**Re: The Northern Road Upgrade (SSI 7127) – Notice of Public Exhibition**

Council welcomes the opportunity to provide comments on the Environmental Impact Statement (EIS) for The Northern Road Upgrade between Mersey Road and Glenmore Parkway.

Figure 5-2 Typical cross section between Mersey Road and Bradley Street (six-lane divided road)

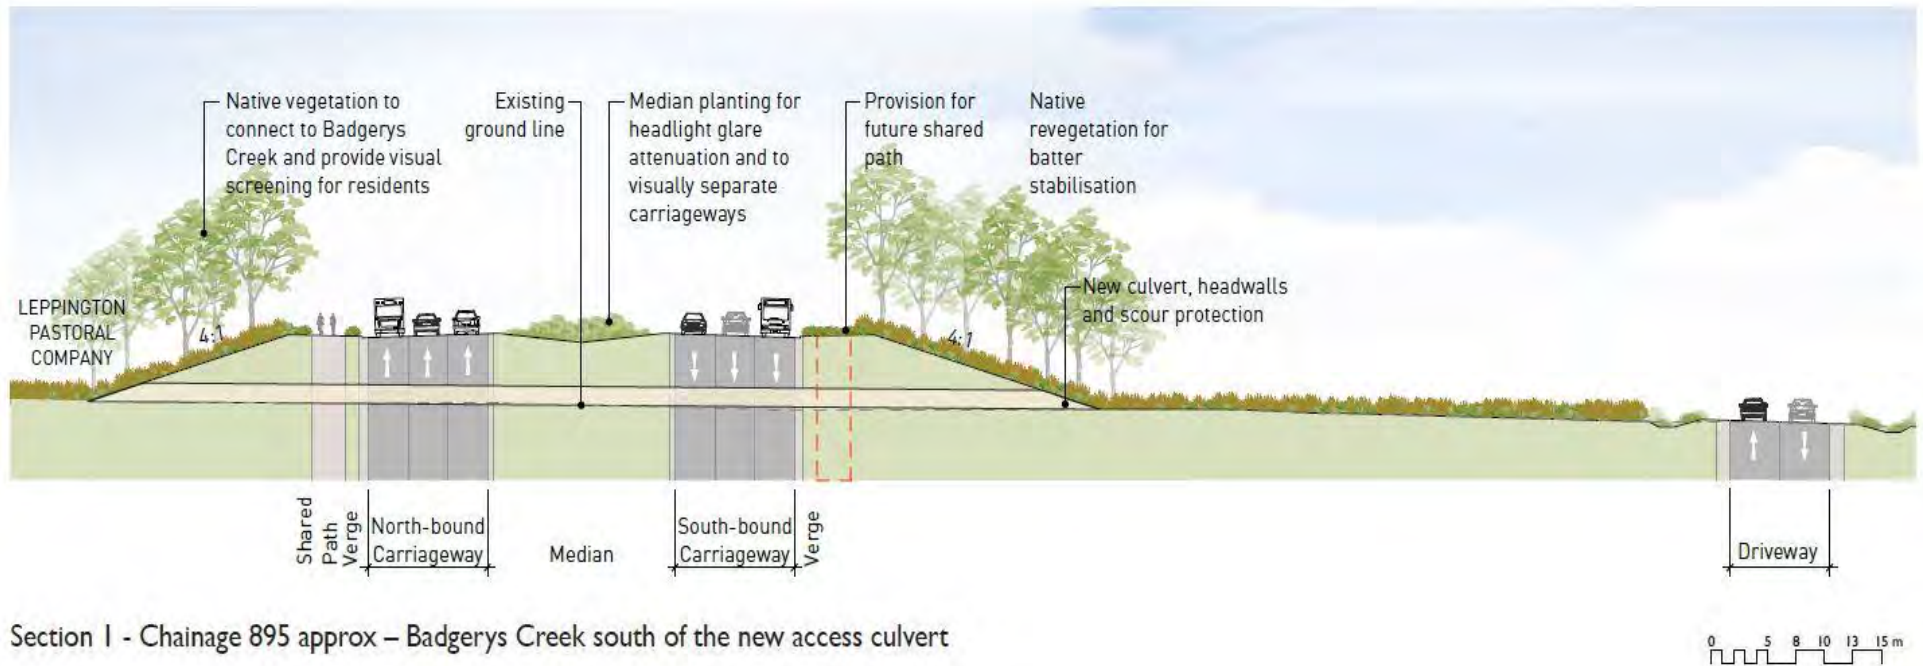
Council notes that the project currently includes a shared path along the western side and a provision of a footpath along the eastern side of the road. The Northern Road is a major north-south regional bicycle route, and it is suggested that in addition to the shared path on the western side, a shared path should be provided along the eastern side.

Figure 5-5 Indicative cross section and elevation of the proposed Adams Road bridge

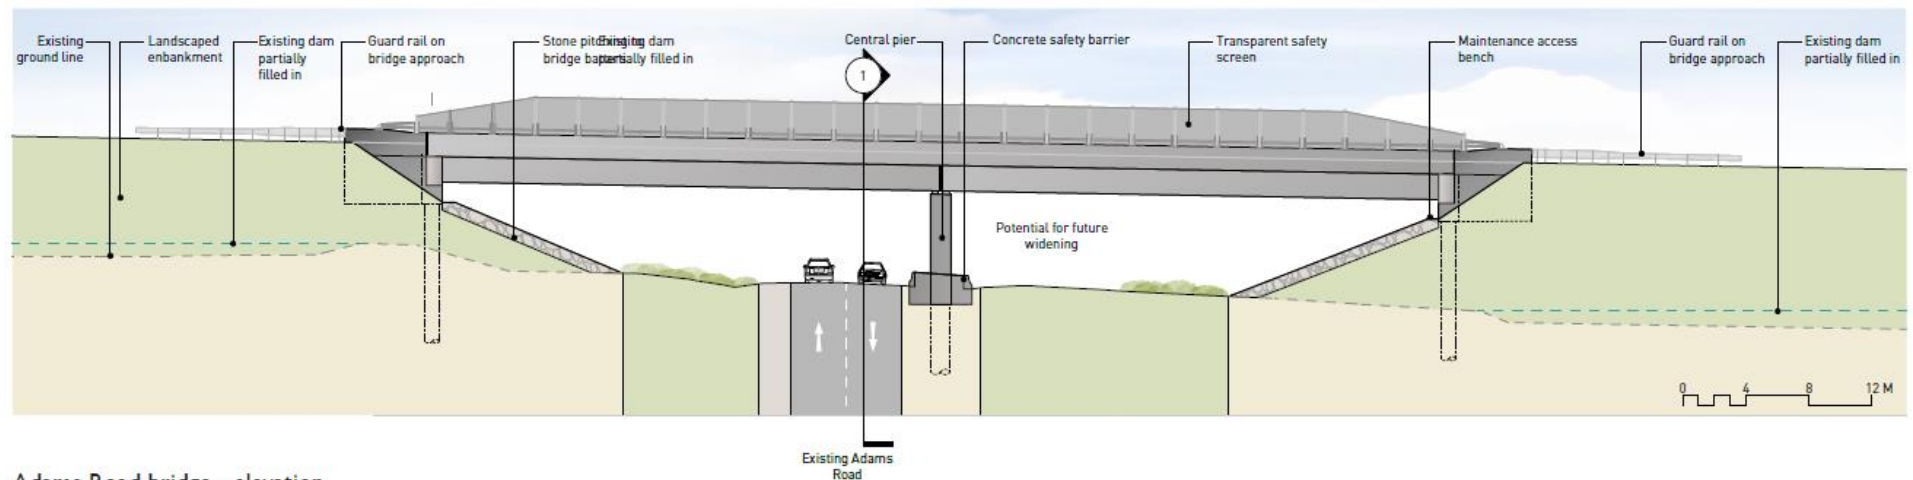
*Adams Road Bridge* - The proposed bridge across Adams Road is to include appropriate provision for future four lane road widening and safety barriers.
